DORAN DRIVE PRECINCT SHOWGROUND

RESPONSE TO STATE DESIGN REVIEW PANEL - MEETING 4

DEICORP PROJECTS (SHOWGROUND) PTY LTD

Please find below a summary of detailed response prepared by the project team to address the items raised in the letter dated 8th April 2022 by State Design Review Panel. State Design Review Panel meeting number 4 was held on 30th March 2022.

GROUND LEVEL PLAN
PROPOSED RETAIL & COMMERCIAL
DORAN DRIVE PRECINCT
DORAN DRIVE, CASTLE HILL NSW 2154
FOR DEICORP PROJECTS (SHOWGROUND) PTY LTD
21015 SK 1.04 S

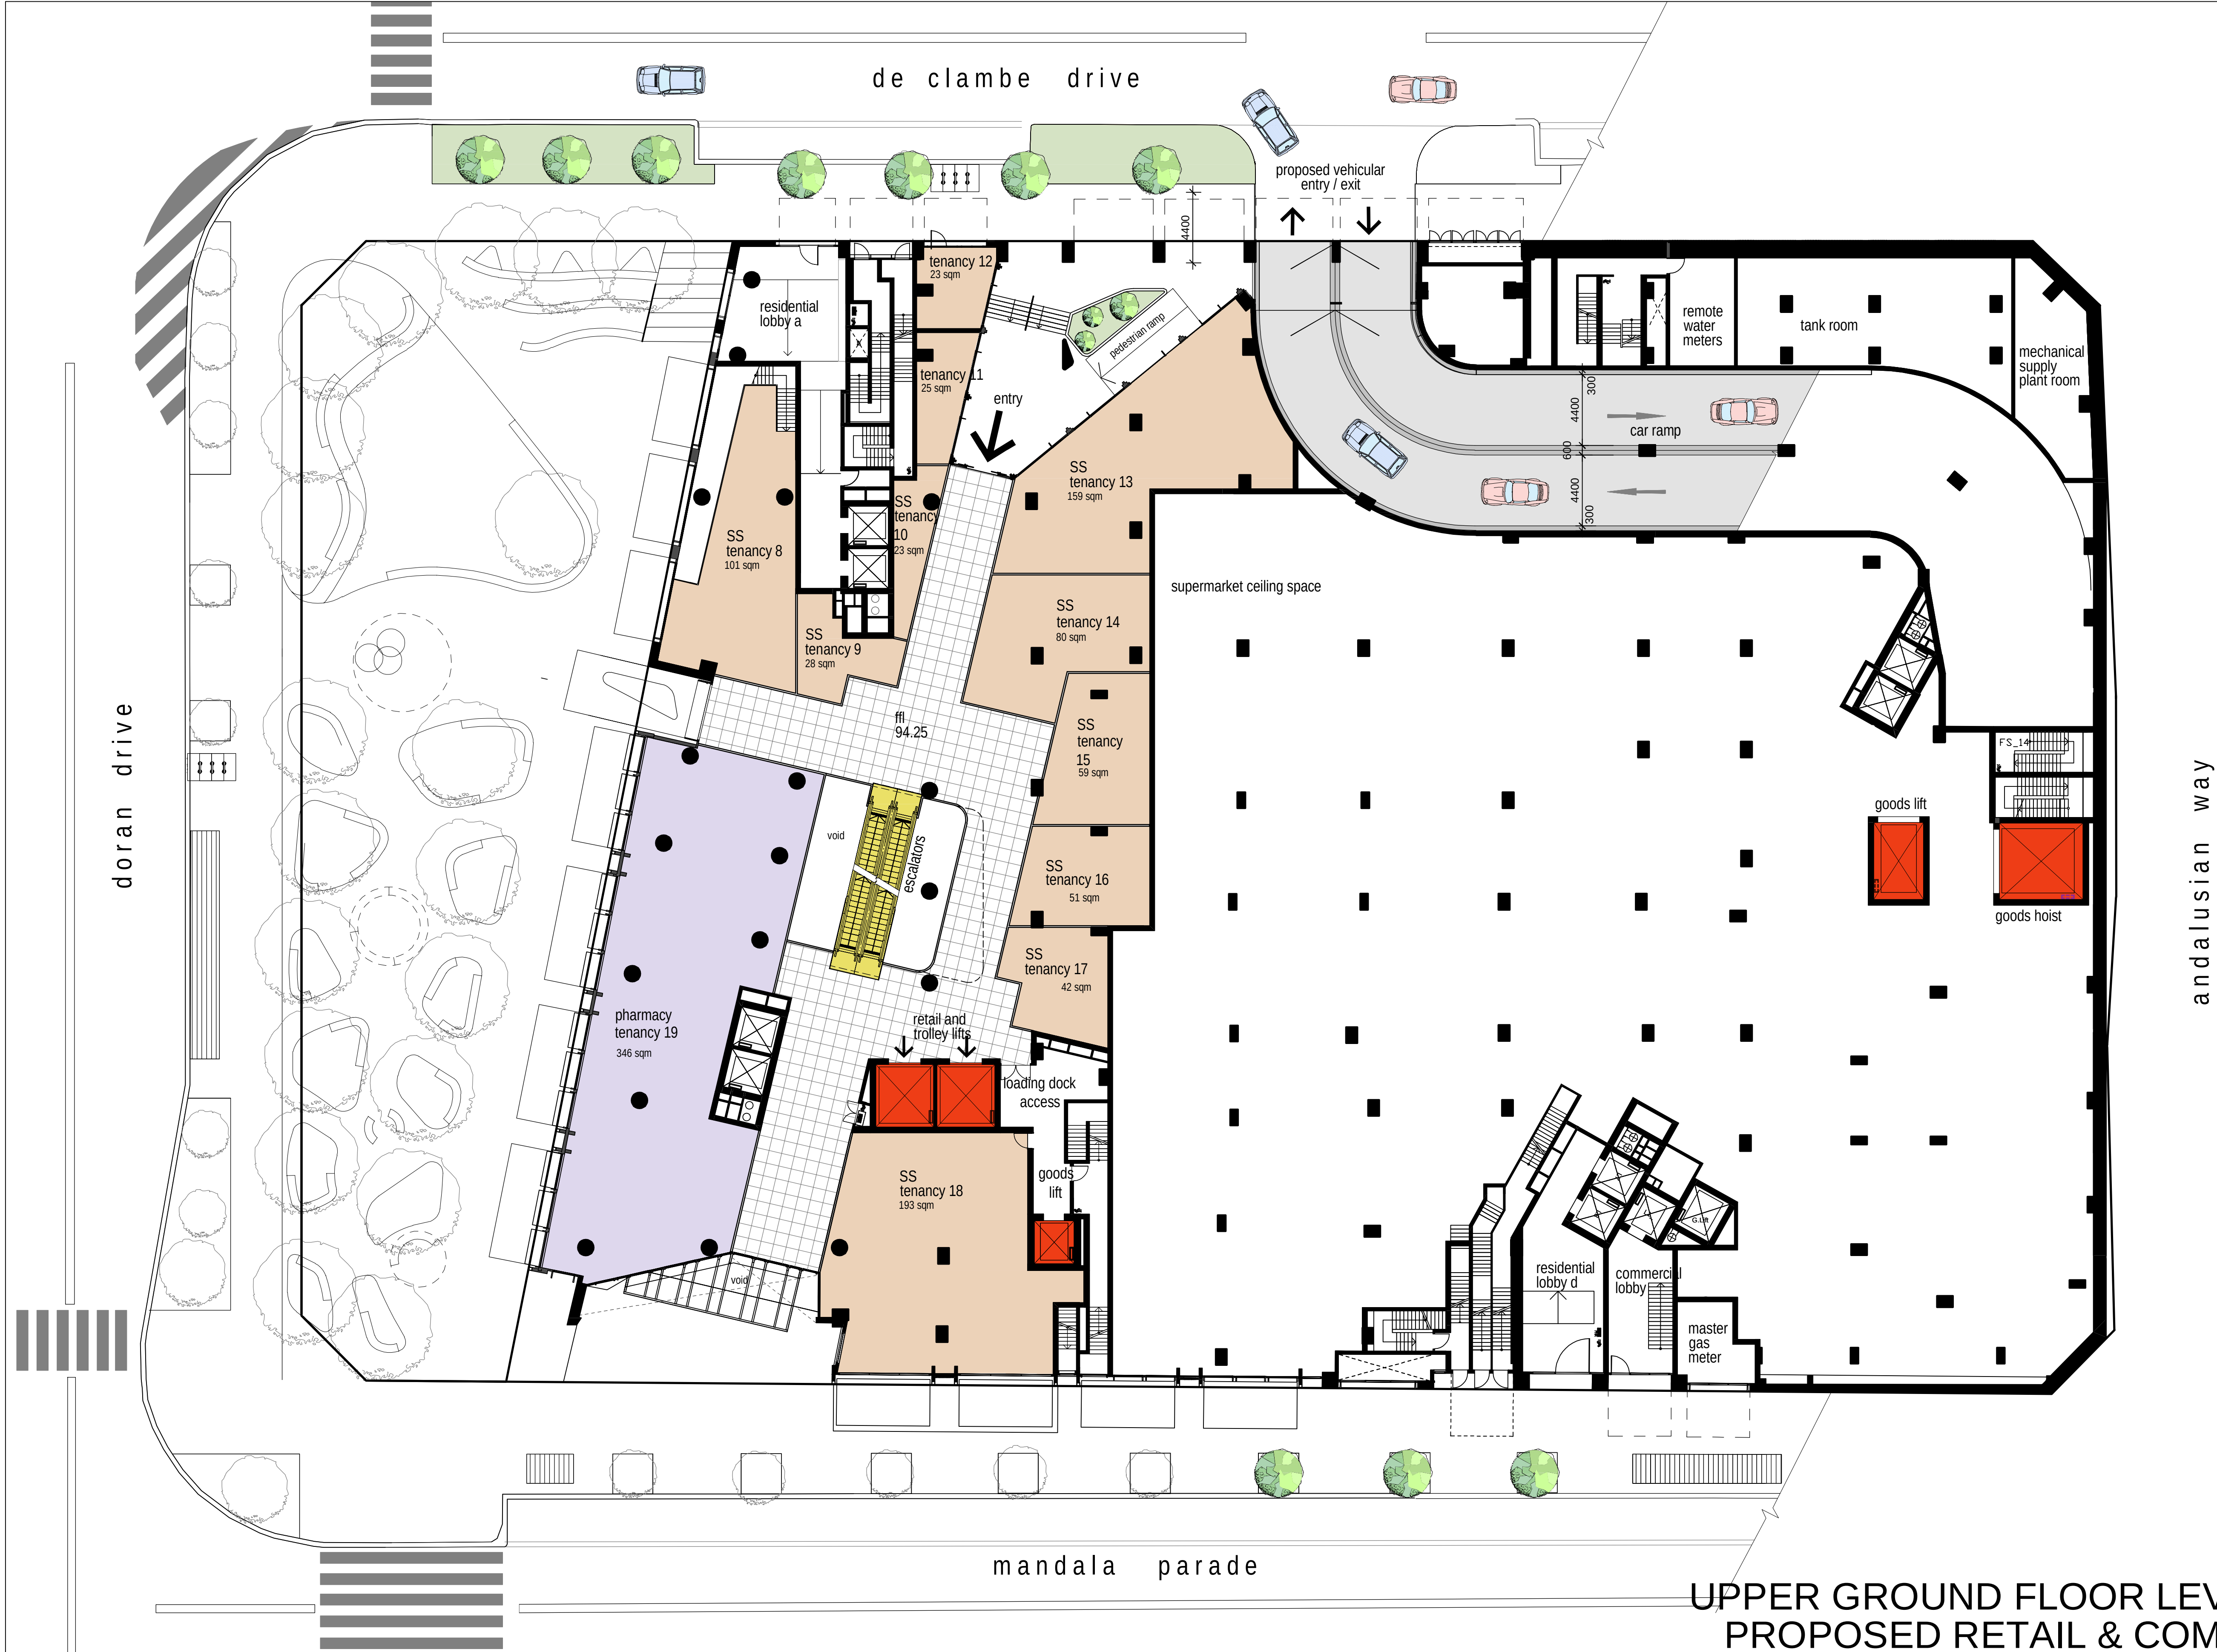
<p>2b. more generous openings to the Doran Drive frontage, similar to entries from Mandala Place and De Clambe Drive. This should also be expressed externally, for example a higher awning along that frontage.</p>	<p>Turner James McCarthy Director / Registered Architect #10759</p>	<p>proximity to daylight at all times will allow for a high-quality retail experience. The retail plan is configured to also allow for clear and unobstructed sightlines to this external glazing that provides a strong visual connection to the immediate context and provides clear unambiguous wayfinding and desire lines. We therefore are confident that the proposal is meeting the panels desired outcome, and merits support.</p> <p>2b. The retail floorplate is modest in size with significant and wide entries at the key connections at Mandala Parade opposite the train station and De Clambe Drive opposite the Showgrounds. The additional Doran Drive Plaza entry compliments the other two more primary entries. The Doran Drive Plaza entry is located mid-way along that street interface to allow for easy and quick connection from the plaza and retail tenancies back into the retail centre and its amenities. It is clearly marked within the façade articulation and aligns the proposed artwork in the plaza. It's current width and clear sight lines are appropriate for the secondary entry point within the retail floorplate. We therefore are confident that the proposal is meeting the panels desired outcome for connectivity, permeability and daylight access, and merits support.</p>
